RE: Marble Brewery (Montgomery)

Grading and Drainage Exhibit

Re: Marble Brewery

9904 Montgomery Blvd., NE Traffic Circulation Layout

PARTIAL RE-GRADE & REPAVE
PLAN
FOR DEVELOPMENT OF
9904 MONTGOMERY BLVD. N.E.
ALBUQUERQUE, NEW MEXICO
MARCH, 2016

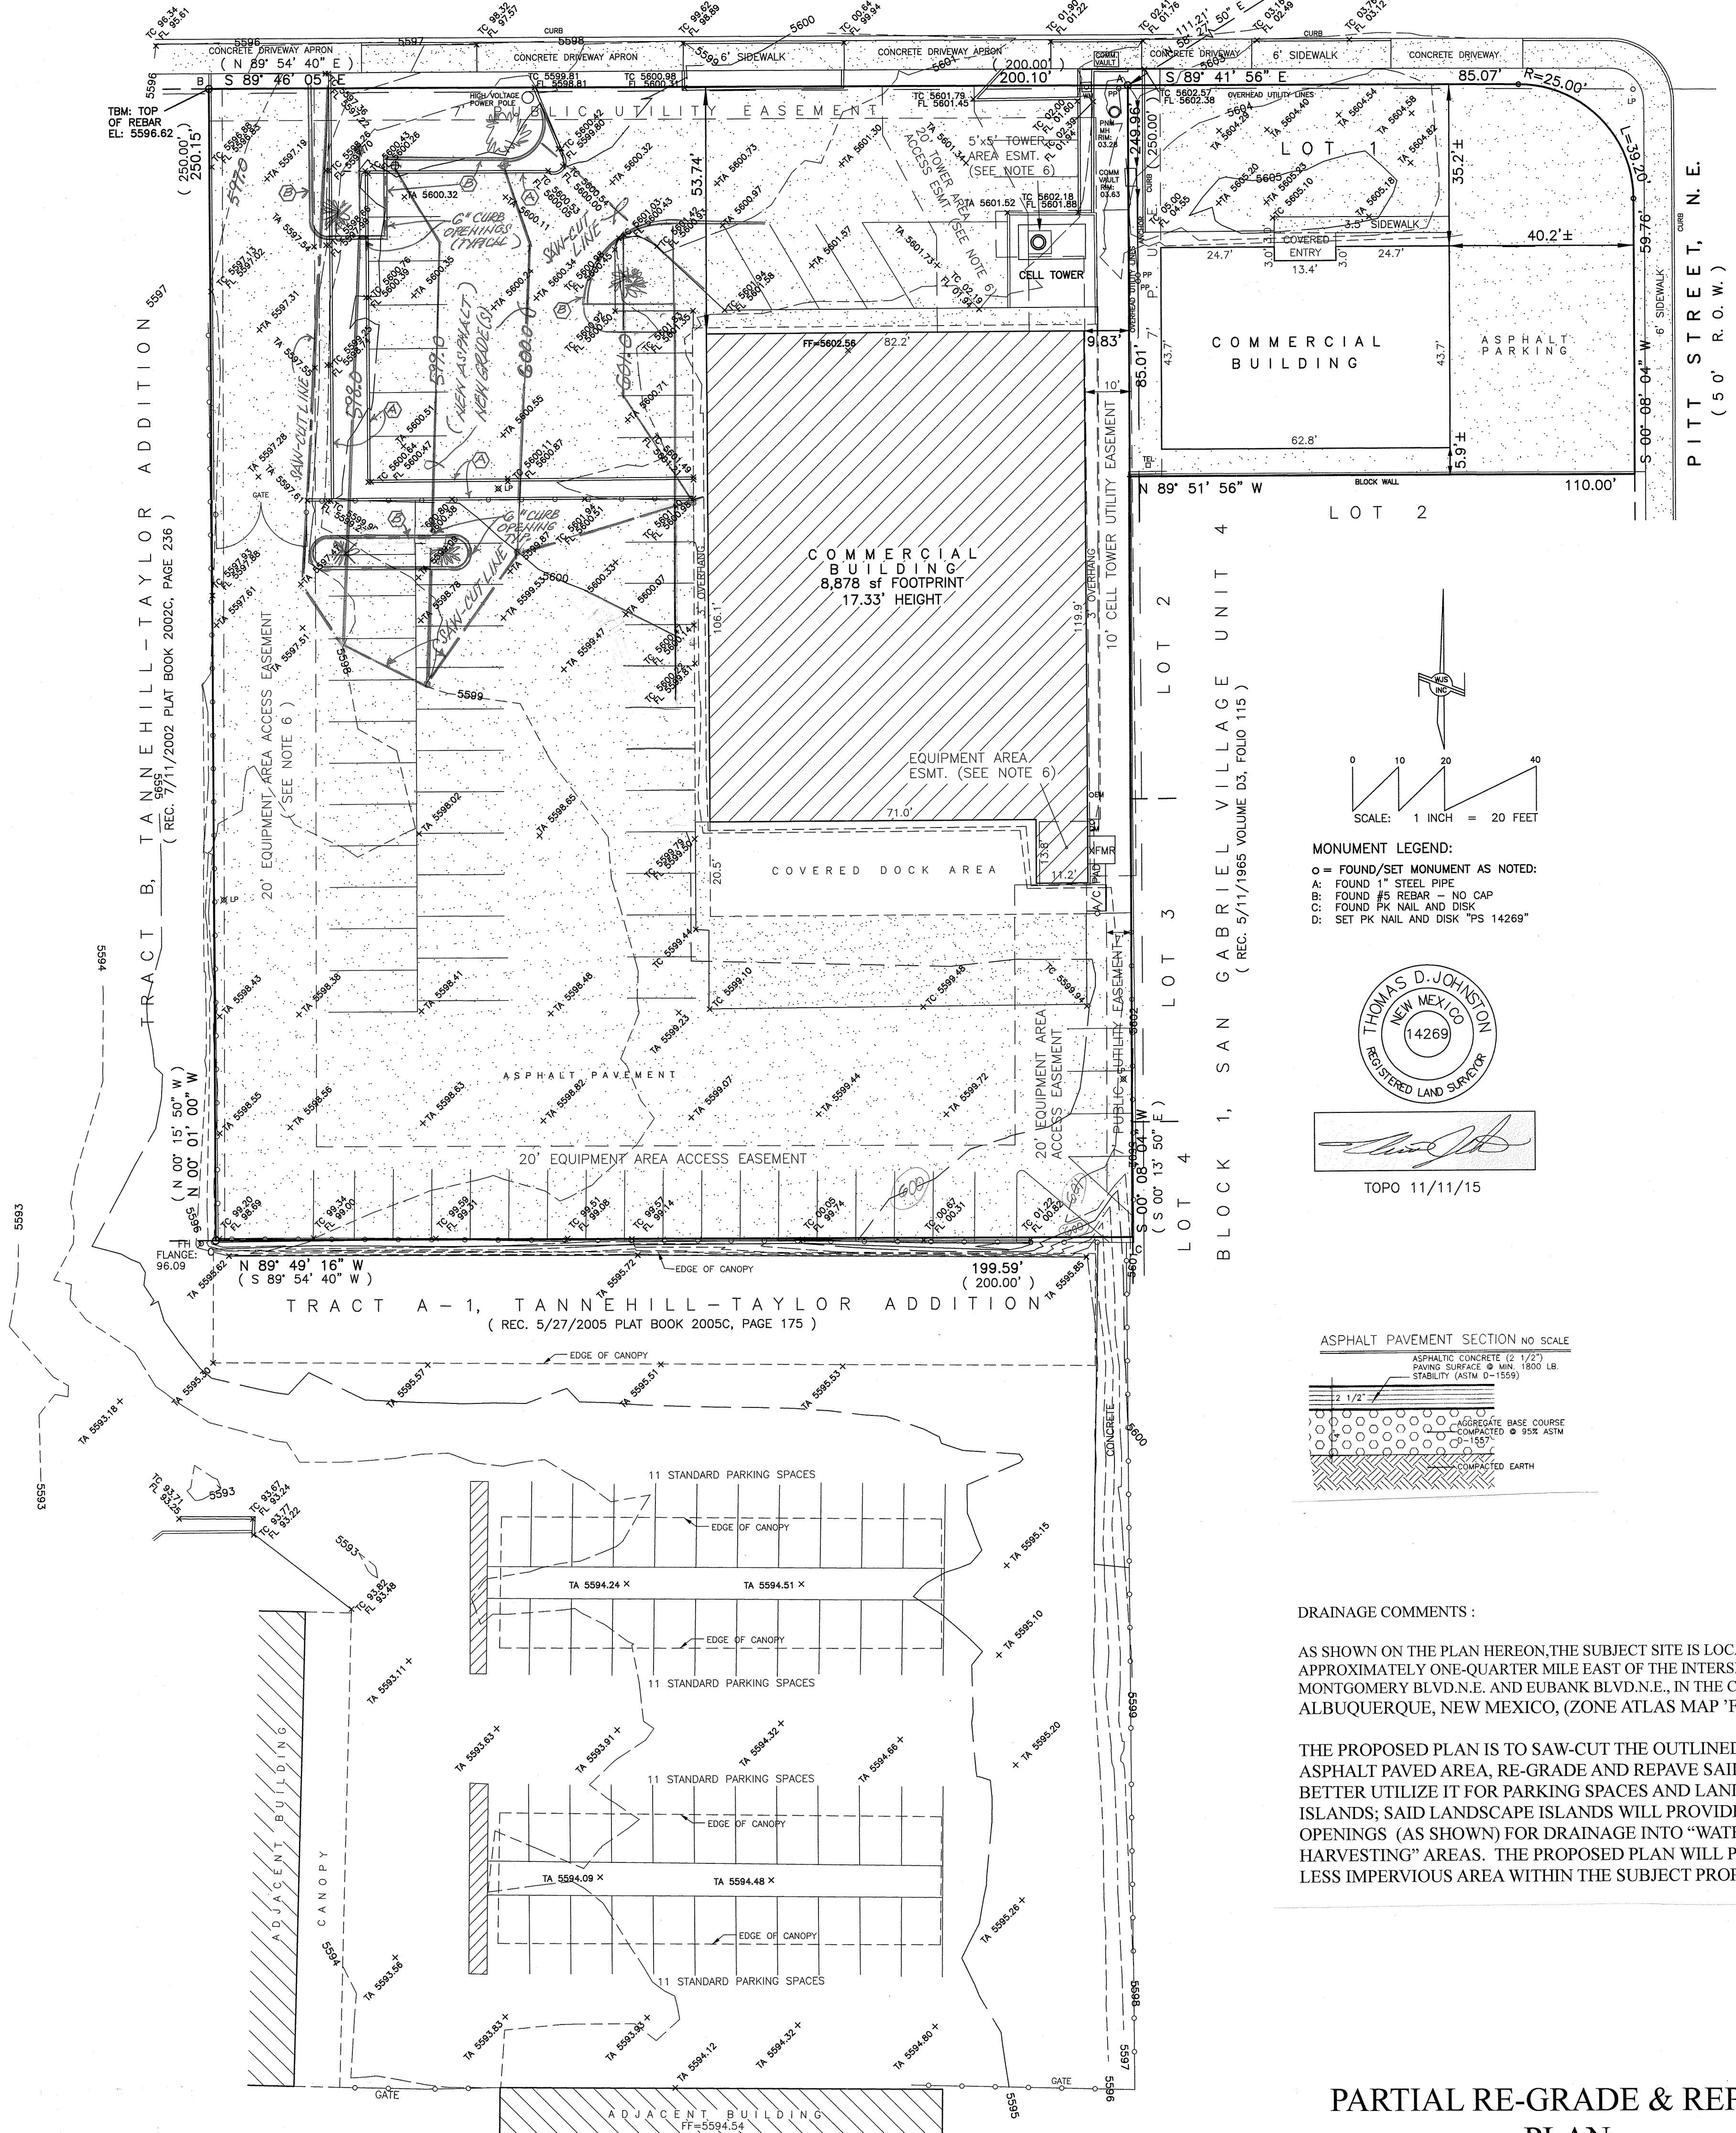
- 10. Provide a min 6" or max 8" high concrete barrier curb or other acceptable barrier between landscaping and parking areas and/or drive aisles. Please call out detail and location of barrier curb.

- 13. It is not apparent what type of pavement surface is being proposed. A hard driving surface will be required as part of this proposed project for parking area and drive aisles.
